BCA ASSESSMENT REPORT

12-16 Bent Street, Lindfield

Project Number: 116856

Date: 9 October 2025

Title  
B1-GENERAL ARRANGEMENT PLANS  
LEVEL 10 FLOOR PLAN

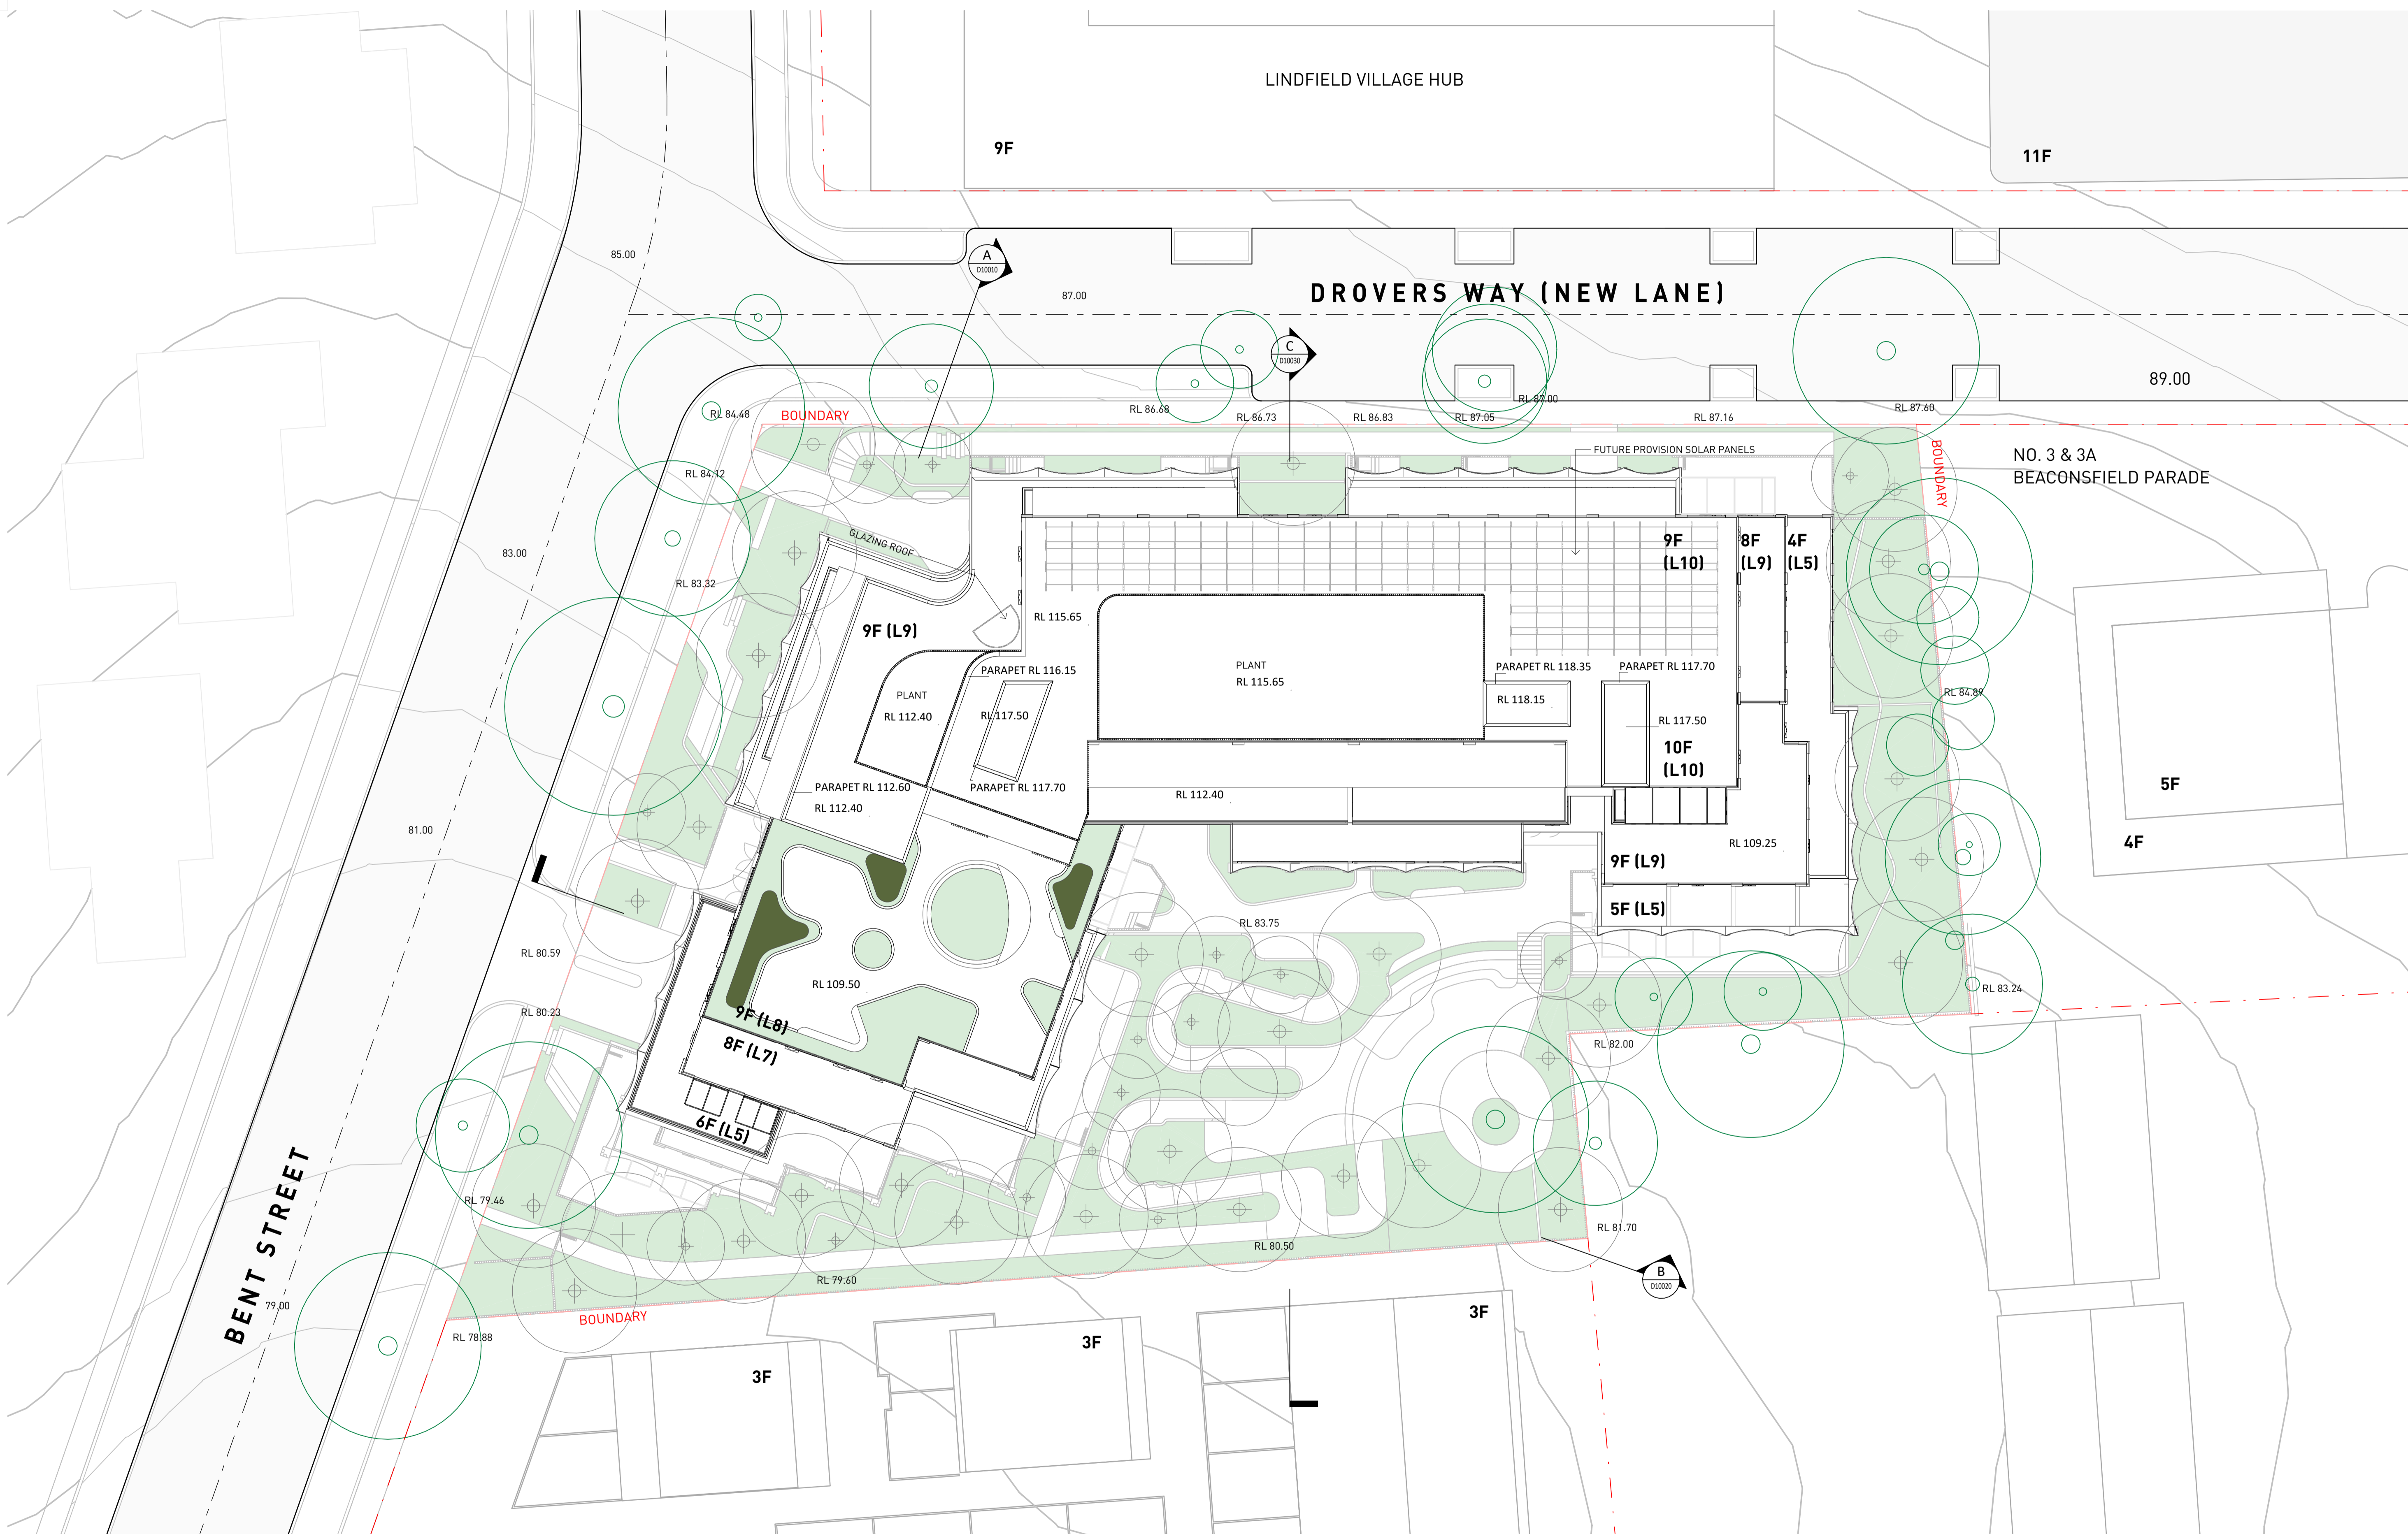
11.	<p>Smoke corridors – Class 2 Address smoke corridors located on Levels 09 and 10 having a length greater than 40m. Design amendments required to achieve compliance, must be divided at intervals of not more than 40m.</p>	C3D15
